The Sizewell C Project

SZC Co.'s Response to the Secretary of State's Request for Further Information dated 18 March 2022: Appendix 2 - Updated Position Statement between SZC Co. and Suffolk County Council (SCC) on matters relating to drainage

UPDATED POSITION STATEMENT
SIZEWELL C DRAINAGE STRATEGY

Sizewell C – Drainage Strategy – Action Plan
Version: 07 (Updated Plan 16th February 2022)
Date: 11/02/2022 – Final 16th February 2022
Parties: SZC Co., ESC, SCC, ESIDB, EA

Plate 4.1: Northern Park and Ride

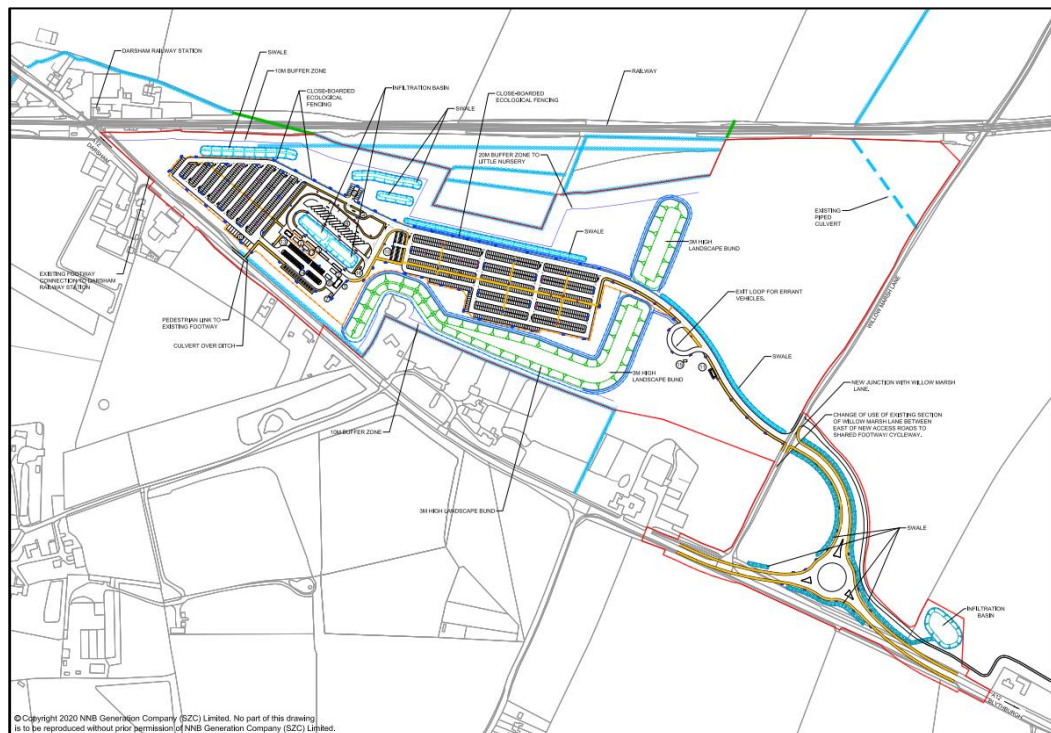
A	B	C	D	E	F	G	H	I	J	K
				At Examination end	Post Examination					
No.	Area	Issue identified	Actions	Deliverable	Deliverable / Ref. No.	Delivery Plan	Deliverable owner	Date	Date issued	RAG / Comment
10	Northern Park & Ride	Lack of evidence for the proposed outfall to two ditches e.g. levels, connection within or outfall beyond Order Limits. Calculations required for the entire site for the proposed surface water drainage strategy. Methodology used to determine Qbar runoff rate is not agreed by SCC, as stated in SCC's response to REP6-024 [REP7-157].	<ol style="list-style-type: none"> SZC to provide evidence and confirm availability of Outfall under A12. (5 l/s if no Inf.) located within the red line boundary. SZC to provide existing topographic survey showing fall in ground level from basin locations to watercourses at the boundary SZC/SCC to hold technical meeting to discuss issues with a view to reaching agreement, informed by supporting information. 	<ol style="list-style-type: none"> Email correspondence providing evidence. Email correspondence providing evidence. Meeting held. 	Update Annex 2A.6: Northern Park and Ride Drainage Design Note as part of final Drainage Strategy.	Incorporate data sent informally in report, and update the source control volume requirements to be split between basins in designated areas.	WSP (DL)	21/01/2022	31/01/2022	Source control modelling validation requirements agreed in meeting 7 th Dec 2021 and incorp in report

Plate 4.3: Freight Management Facility

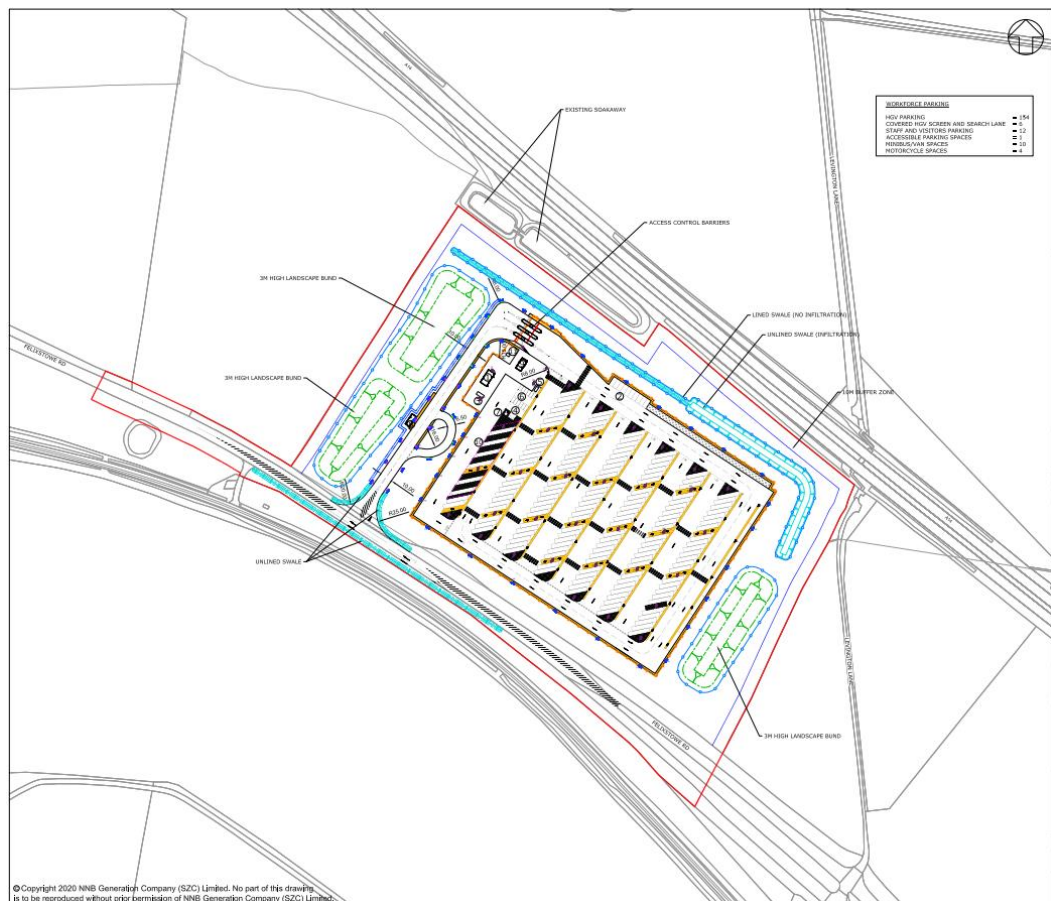
A	B	C	D	E	F	G	H	I	J	K
				At Examination end	Post Examination					
No.	Area	Issue identified	Actions	Deliverable	Deliverable / Ref. No.	Delivery Plan	Deliverable owner	Date	Date issued	RAG / Comment
12	Freight Management Facility	Below ground attenuation is not compliant with Local Plan Policy SCLP9.6, Only FSR rainfall (least conservative) has been applied to calculations. No climate change allowance has been modelled.	<ol style="list-style-type: none"> SZC Co. provide explanation why temporary underground storage is reasonable. SZC/SCC to hold technical meeting to discuss issues with a view to reaching agreement, informed by supporting information. Open discussions with adjacent landowner (Home Farms) as to potential receipt of excess surface water. 	<ol style="list-style-type: none"> Note provided informally to SCC on basis for underground storage approach. Meeting held. Not progressed. 	Update Annex 2A.8: Freight Management Facility Drainage Design Note as part of final Drainage Strategy. Use output above as basis to open discussion with landowner.		WSP (DL)	21/01/2022	21/01/2022	SCC have indicated likely acceptance of underground storage providing some surface level SuDS pollution measures are incorporated. Landowner opportunity discussion to be held at design stage if SCC reject underground storage. Comments received Review of space for rain garden

EW0320	18	12	-	Report - Freight Management Facility Drainage Design Note	The main outstanding concern SCC have for FMF is in relation to treatment. The document makes multiple references to the use of bioremediation areas in order to supplement proposed treatment and to provide a natural form of treatment, as opposed to the 'mechanical heavy' treatment train previously proposed. Appendix B does not make any acknowledgement of the space requirements of bioretention features and Appendix E does not include these features in a pollution assessment. This approach does not have SCC support. The current pollution assessment in Appendix E uses indices for 3 pieces of infrastructure without supporting evidence of the values used. The indices for the underground storage tank are particularly questionable as I have never seen anyone claim that such a feature delivers any form of treatment. There is a brief reference to bioretention in the conclusion, but again, this is insufficient.	Matt Williams - SCC	31/01/2022	Derek Lord - WSP	No	Closed	2	Report issued 21/01/2022 Comment noted	Show location of bioremediation infrastructure on layout plans Confirm sizes and demonstrate available space Add bioremediation to Appendix E calculations Provide manufacturers certification of indices values

Plate 4.4: Sizewell Link Road

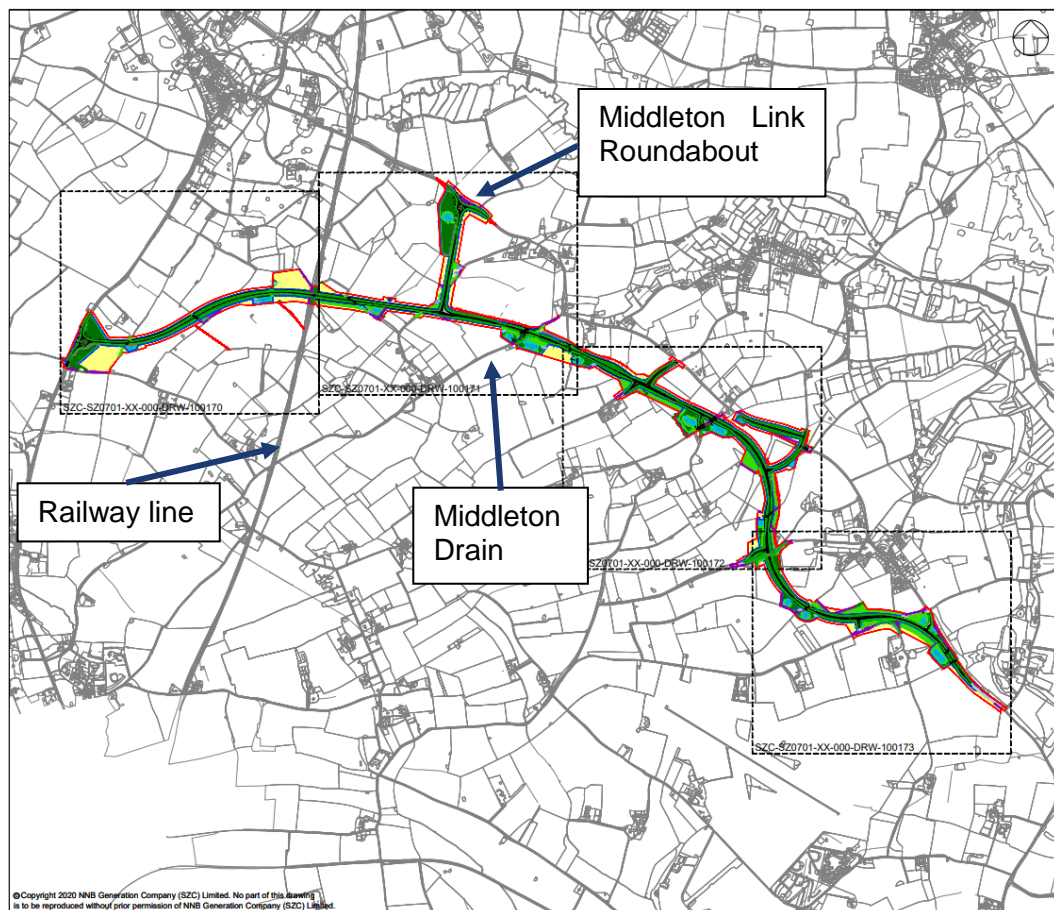
13	Sizewell link road.	SCC concern with swales at the base of embankments rather than at the top.	<ol style="list-style-type: none"> SZC Co. to hold discussion with SCC to resolve this issue or design to be modified to move swales to top of embankment at future stage. Informed by cross sections. Additional item: Provide updated calculations. 	<ol style="list-style-type: none"> Email correspondence provided. Shown on preliminary design drawings and in technical note provided. Not provided. 	SZC Co. to update Annex 2A.9: Sizewell Link Road Preliminary Drainage Design Note, including cross sections and calculations note, as part of final Drainage Strategy.	SCC to review and respond to information provided. Agree design criteria governing location of swale.	WSP (DL)	09/02/2022	11/02/2022	No SZC action pending SCC response on swale location

Plate 4.5: Yoxford Roundabout

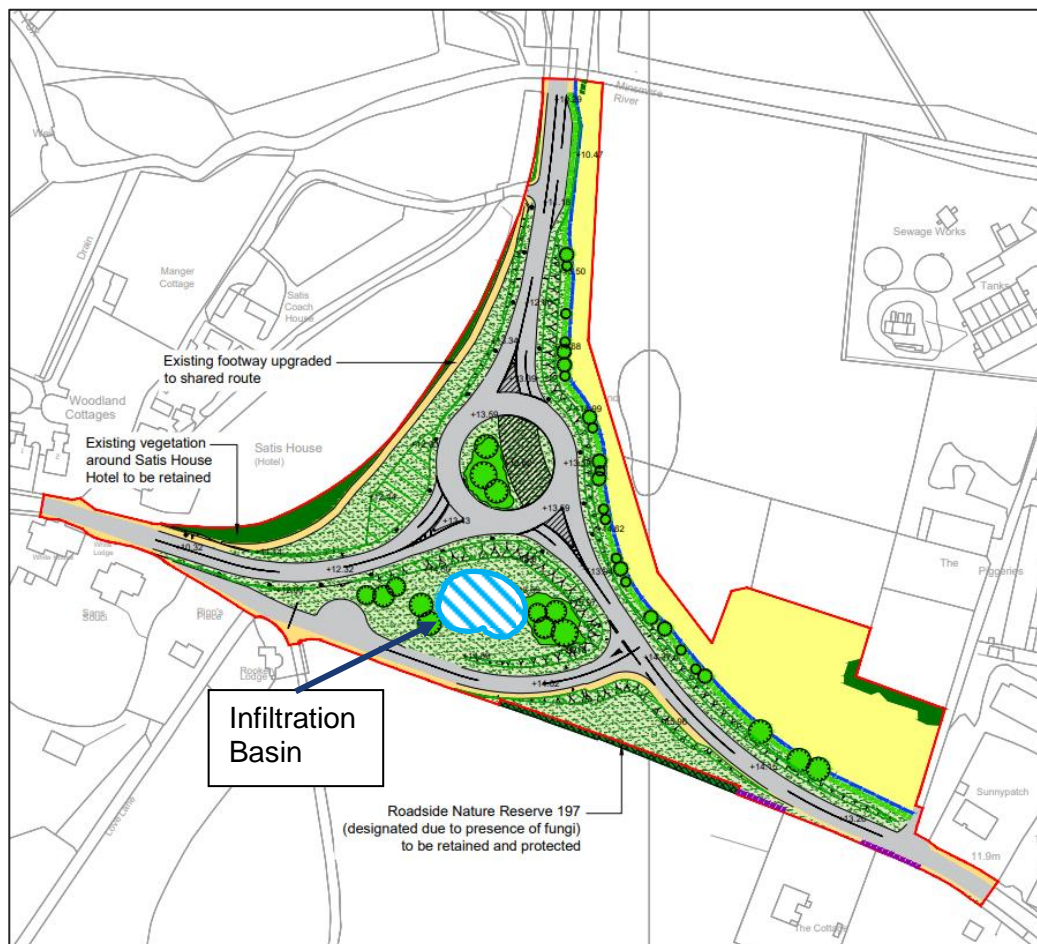
15	Yoxford roundabout (new item)	Deep infiltration – SCC will not consider design solution until EA has approved a ‘deep infiltration’ approach.	SZC Co. to: 1. Provide additional information on basin and berm design, including potential for tree planting. 2. Describe alternative solution to avoid ‘deep infiltration’ design.	1. Email correspondence and information provided to SCC. 2. Provided in email correspondence.	Update Annex 2A.10: Yoxford Roundabout Updated Drainage Strategy as part of final Drainage Strategy.	Liaise with EA over potential design constraints to basin depth. Subject to above outcome, develop alternative option (e.g. pumping or gravity). EA Meeting held on 12/01/2022	WSP (DL)	11/02/2022	11/02/2022	EA Engagement agreed

Plate 4.6: Two Village Bypass

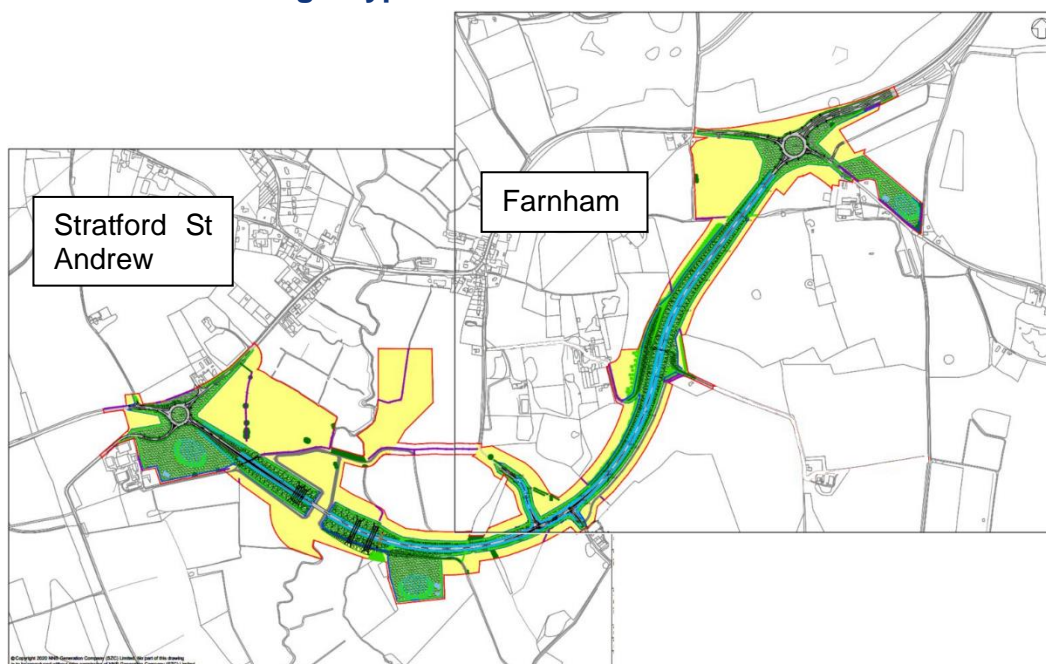
A	B	C	D	E	F	G	H	I	J	K
				At Examination end	Post Examination					
No.	Area	Issue identified	Actions	Deliverable	Deliverable / Ref. No.	Delivery Plan	Deliverable owner	Date	Date issued	RAG / Comment
14	Two Village Bypass infiltration Basin 2 East of River Alde Embankment	Positioning of basin further from the highway to be adopted and separated by the farm access track. High infiltration rate could indicate a direct connectivity to the aquifer which could cause water quality issues.	SZC Co. to: 1. Hold meeting with SCC to understand nature of concerns. 2. Review proposed position of basin and demonstrate that it works hydraulically and that there is no alternative to the alignment of the farm access track. 3. Provide data / evidence relating to basin and aquifer. 4. Additional item: Resolve potential discrepancy between GI infiltration data and input data to modelling.	1. Meeting held. 2. Email correspondence and information provided to SCC, including proposed embankment materials. 3. Email correspondence and information provided to SCC. 4. Not provided.	Update Annex 2A.11: Two Village Bypass Preliminary Drainage Design Note as part of final Drainage Strategy. To include clarification on infiltration input data.	Hold technical meeting to resolve basin location disagreement. Updated hydraulic modelling using updated infiltration rates Engagement with EA on Borehole soakaway	WSP (DL)	11/02/2022	16/02/2022	Hydraulic Update

Plate 4.7: Green Rail Route and Rail Extension

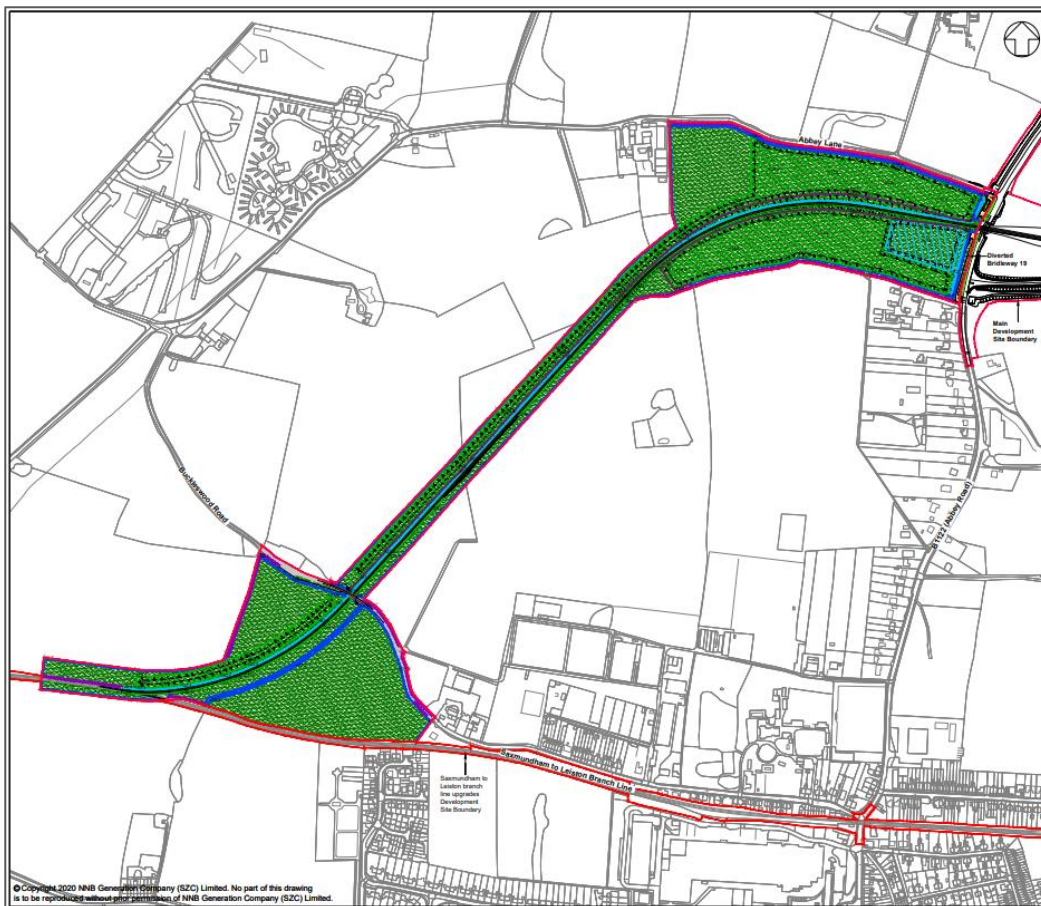
A	B	C	D	E	F	G	H	I	J	K
				At Examination end	Post Examination					
No.	Area	Issue identified	Actions	Deliverable	Deliverable / Ref. No.	Delivery Plan	Deliverable owner	Date	Date issued	RAG / Comment
16	Green rail route (new item)	No drainage technical note provided to support the Drainage Strategy.	SZC Co. to: 1. Provide drainage technical note to support the Drainage Strategy.	1. Annex 2A.12: Green Rail Route Drainage Design Note provided within D10 Drainage Strategy .	Update Annex 2A.12: Green Rail Route Drainage Design Note as part of final Drainage Strategy.	Resolve residual issues on storage volumes in respect to 1 in 100 +CC storm. Part 1 Preliminary Design, initial modelling, PIMP note for rail Part 2 Detailed modelling and update	WSP (DL) / Atkins (MS)	Part 1 11/02/2022 Part N/A	11/02/2022	Hydraulic modelling is required for demonstrate a viable solution.
17	AD6 – MDS Highways	SCC commentary on Examination submission to be confirmed	SCC to: 1. Provide review comments on items REP10-030 , REP10-031 and REP10-032 submitted	1. Submissions made into PINS and to SCC of information that was not reviewed due to timescales	SCC comments on submissions REP10-030 , REP10-031 and REP10-032 Update of Technical Report	Receive comments Update report	DCC (MW) WSP(DL)	17/12/21 11/02/2022	Issued email 16/12/2021 SCC (MW) Comments received 04/01/2022 Reissued 11/02/2022	SCC undertaking review of info submitted. SCC clarification of 13 th Jan 2022 to be discussed at next progress meeting
